From: Adam King [REDACTED]
Sent: 16 September 2019 18:13
To: Zac Denton <Zac.Denton@arun.gov.uk>
Subject: RE: K/19/19/HH Little Tangle, Middle Way, Kingston Gorse

" K/19/19/HH Little Tangle, Kingston Gorse. The proposed development involves more than a simple extension to the existing property. The proposal involves raising the roof height to 15.4 metres creating a new dwelling level at first floor height and adding a balcony at that level. This would result in significant overlooking of the properties and gardens on either side of Little Tangle and there is no evidence in the application as to how this might be avoided or mitigated. Additionally, the proposal is to provide grey slate for the new roof and this would be out of keeping surrounding properties which are provided with clay tiles and/or Horsham stone and is therefore contrary to policy D DM1 (1) of the Arun Local Plan."

Proposed Section AA

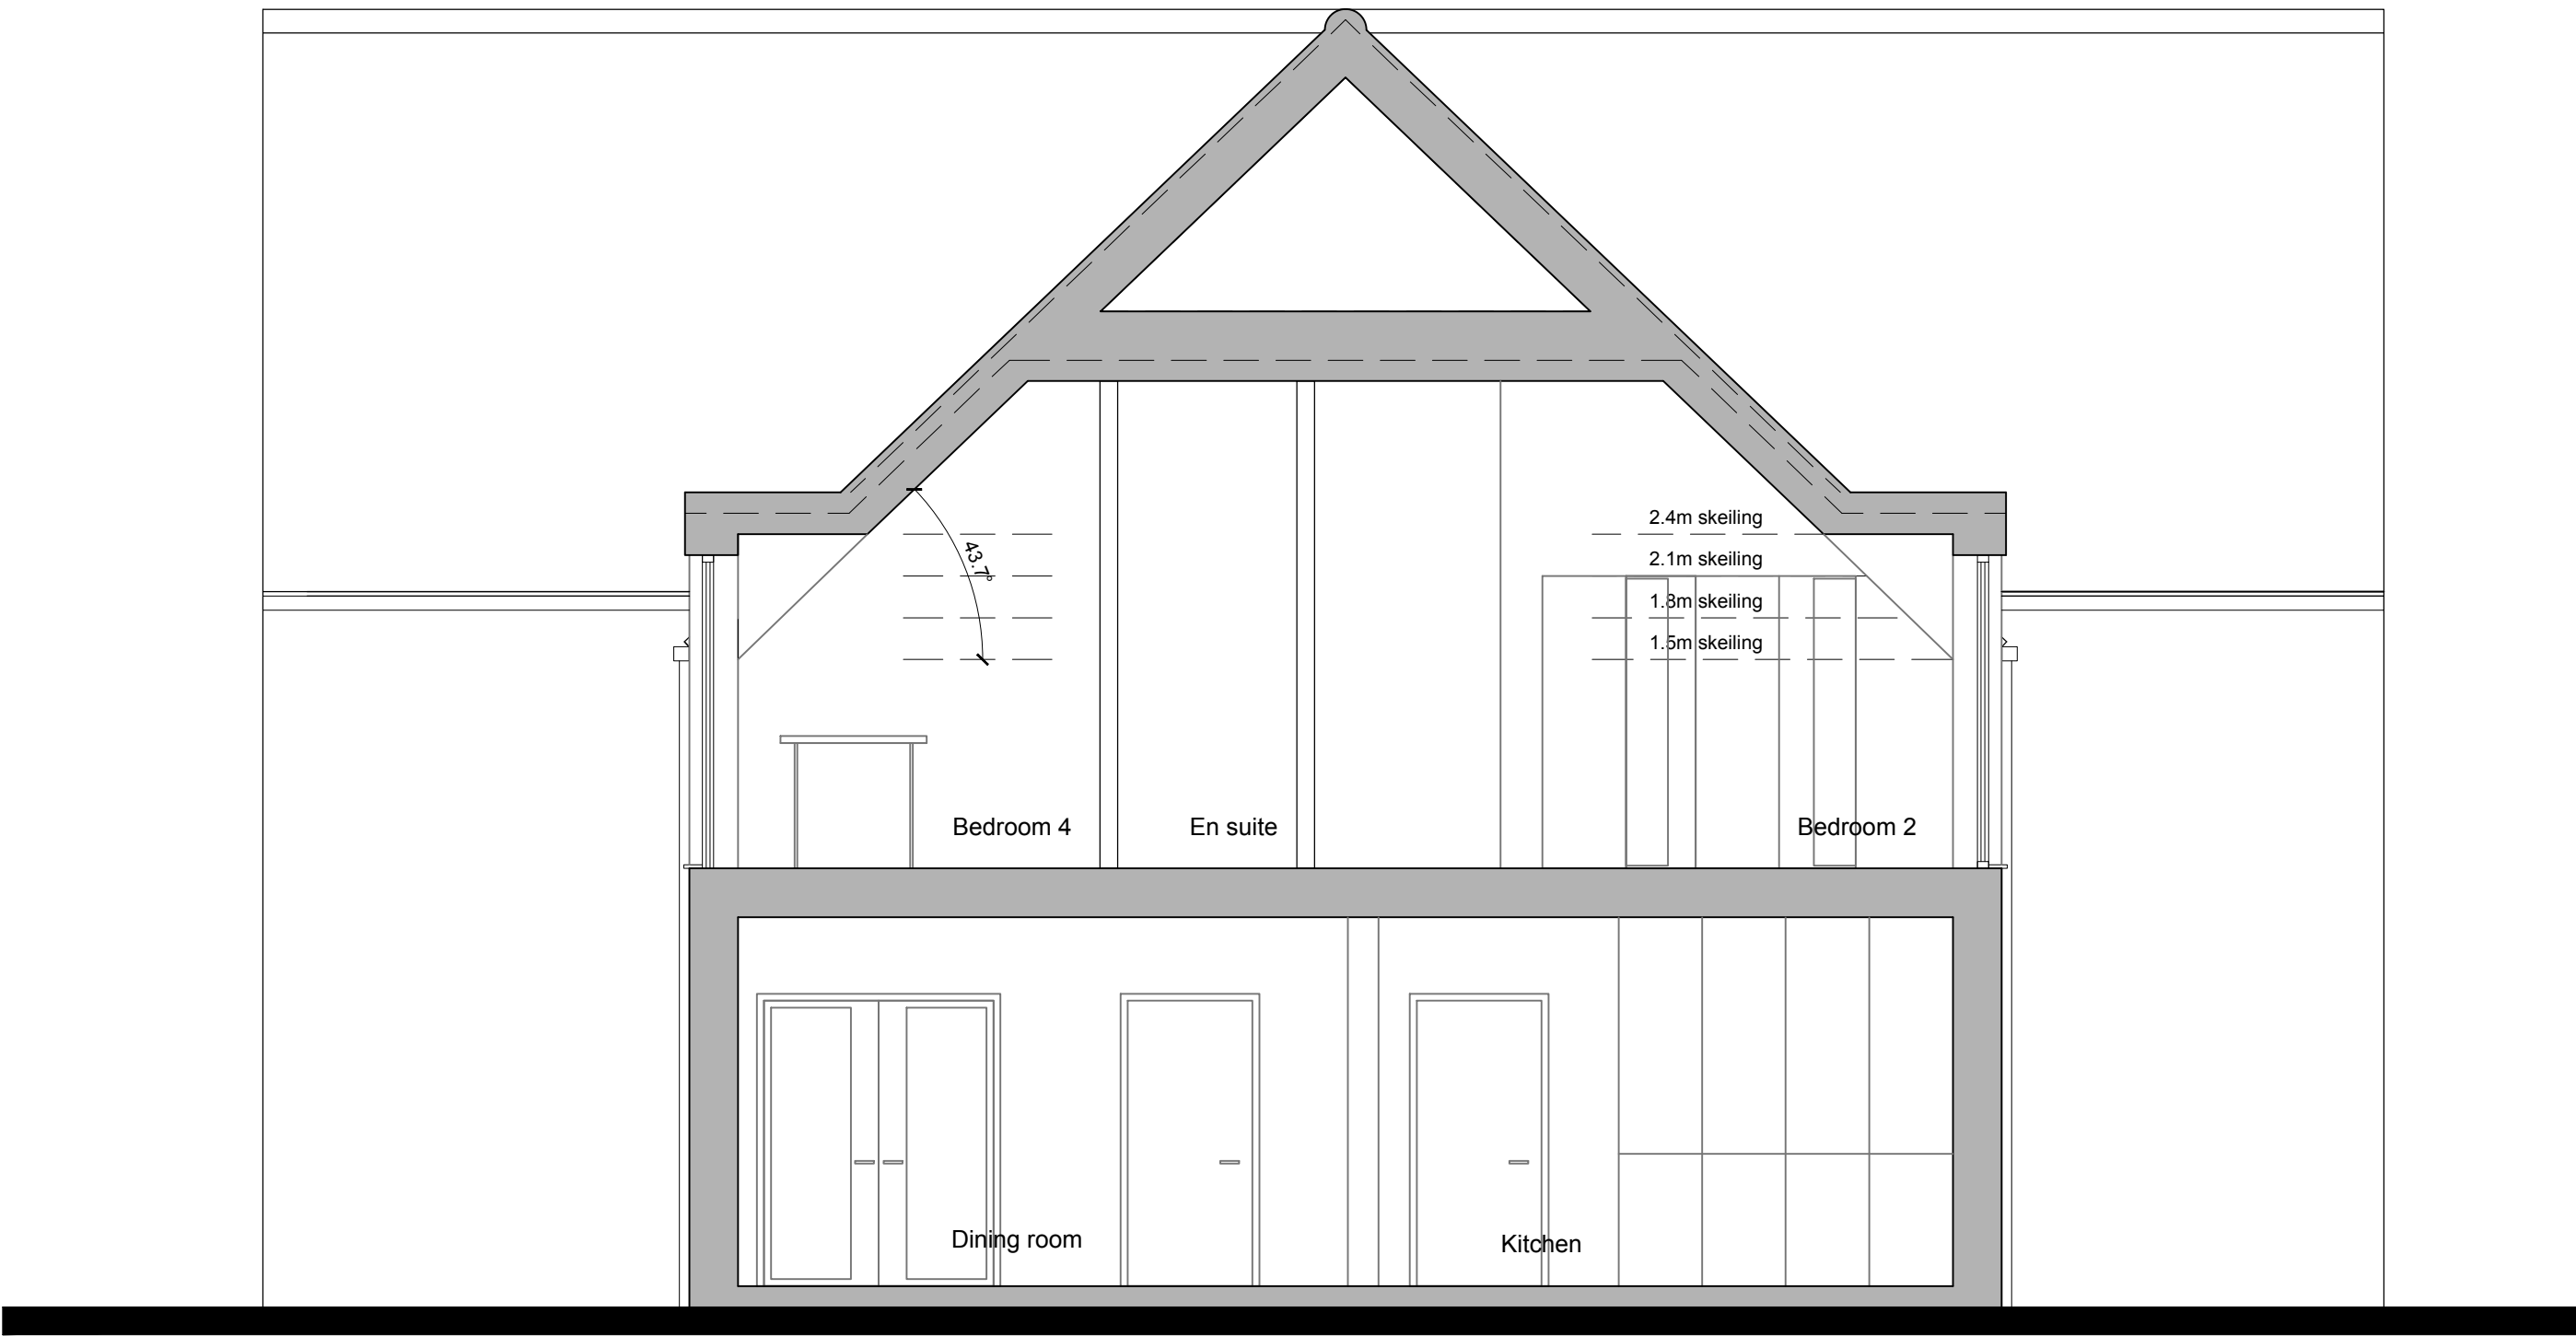
- The Cllr. notes that the proposal involves raising the roof height to 15.4 metres. As you know, this is the AOD figure from the survey information, and not a true height.

- To report accurately, the new eaves height from the ground is 4.652m high, and the **highest** point of the ridge is 9.320m high from the ground. The existing buildings ridge height is 6.080m high.
